MEMORANDUM

TO: Jean Fraser, Planner
FROM: David Senus, P.E.
DATE: May 5, 2014
RE: 97 Cumberland Ave Multi-family, Level III Site Plan Application

Woodard & Curran has reviewed the Preliminary Level III Site Plan Application for the proposed multi-family building located at 97 Cumberland Ave in Portland, Maine. The project consists of creating a “high-performance” 5 unit multi-family building on an infill redevelopment lot along Cumberland Ave in Portland.

Preliminary Site Plan

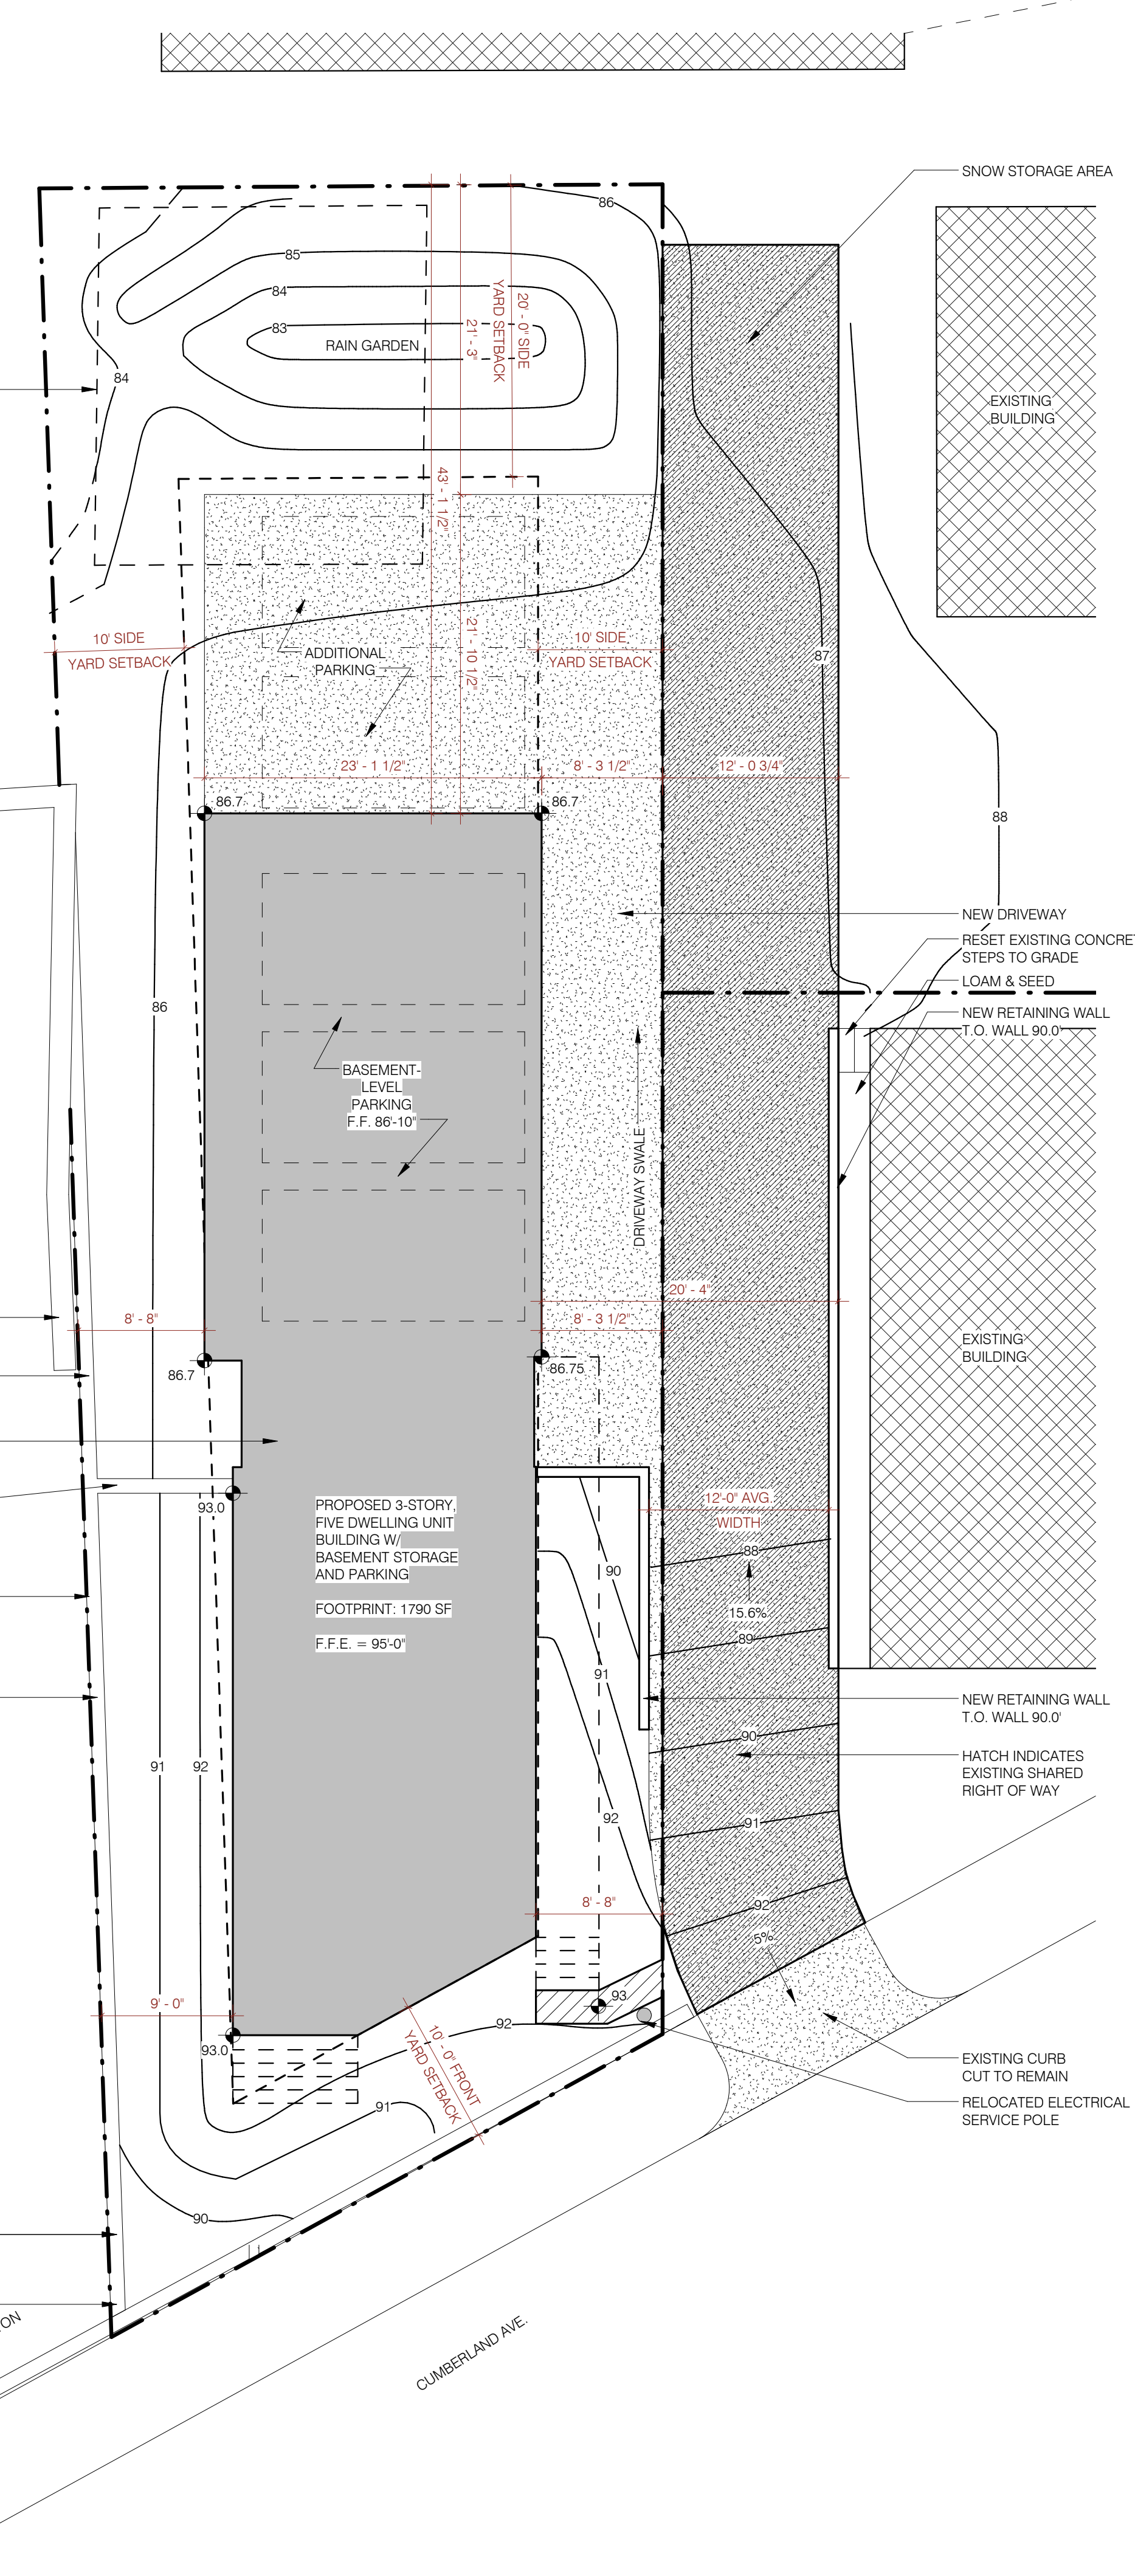
- 2) The Applicant should clarify whether the project will result in an increase of approximately 2,900 square feet of impervious area, as stated in the application form and the text of the stormwater management plan, or approximately 2,300 square feet as noted in the treatment calculations.

- 7) How will roof drainage be managed from the proposed building?
- 8) The existing site includes a utility pole that provides overhead service (presumably both electrical and telecommunications) to buildings on three adjacent properties. The plan calls for eliminating this pole and the associated existing overhead services; however, it does not address how new services will be provided to all adjacent properties, specifically the 7-Eleven store.

INFILTRATION POND
NOT TO SCALE

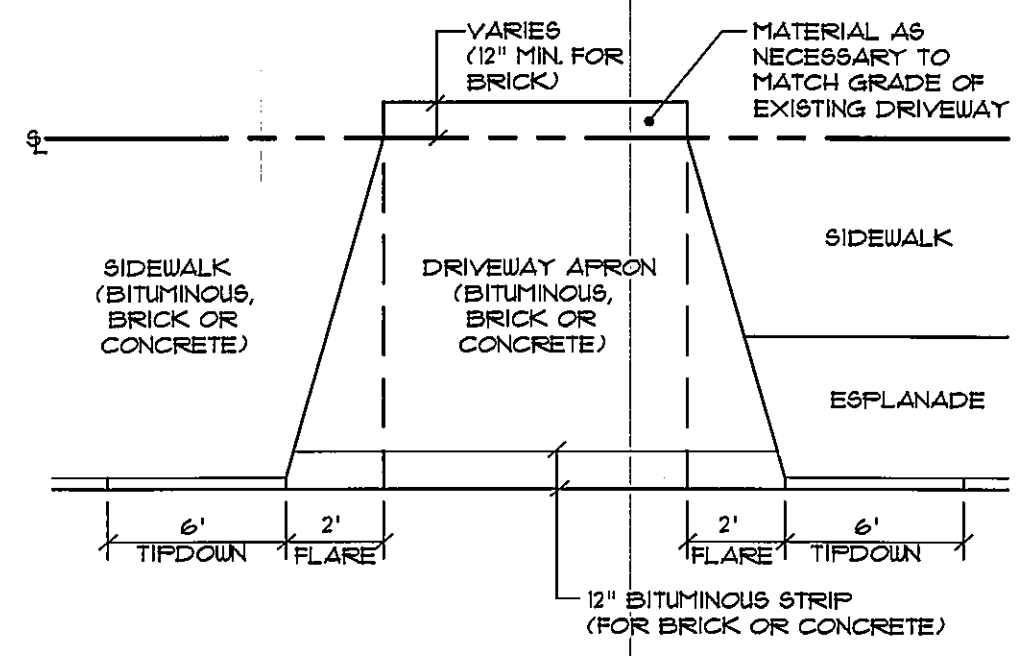
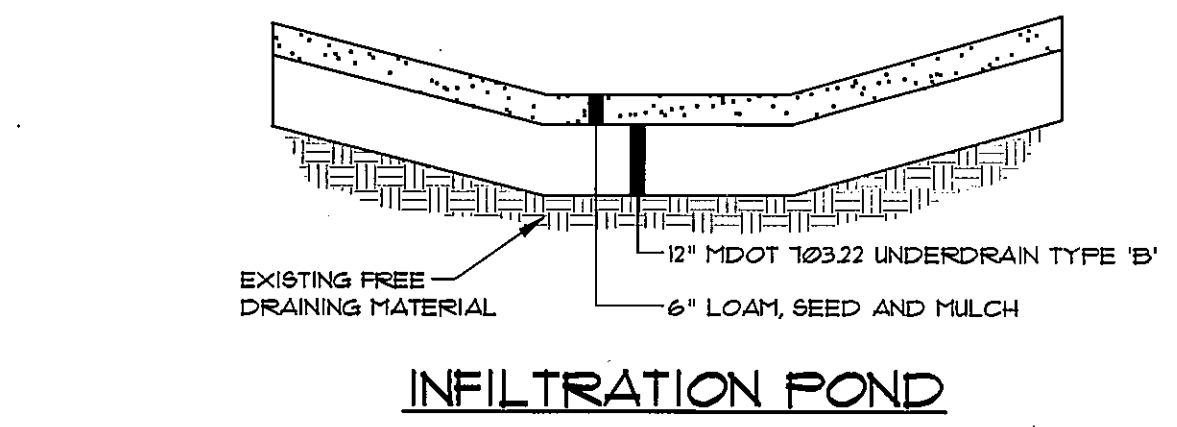
- 5) The proposed infiltration basin is located partially within the footprint of the former house structure. Has the building foundation been fully demolished and removed. What are the drainage characteristics of the fill materials that have or will be utilized in this area? Has the Applicant performed a test pit or boring to evaluate the soil characteristics or infiltration capacity? How deep is bedrock at this location?

- 6) The Applicant proposes a rip-rap spillway to manage overflow from the proposed infiltration basin. Overflow from this spillway will drain west, below a stockade fence, across a fenced dumpster area on the 7-Eleven property, and across the 7-Eleven parking lot to the Washington Avenue drainage collection system. The applicant notes that this route is similar to the pre-development drainage pattern (existing condition); however, a review of the HydroCAD model indicates that more area will be directed to this location in the post-development condition, and although the infiltration basin will provide minor detention, the model predicts an increase in runoff rate at this location (from the spillway) in the post-development 10- and 25-year storm events. The drainage design should be revisited to eliminate directing overflow onto the neighboring property, unless the Applicant obtains drainage easements from N/F Ginn Portland LLC and modifies the adjacent fence and dumpster/parking area to accommodate drainage from the site. The Applicant should propose an alternative means of managing overflows from the infiltration basin.
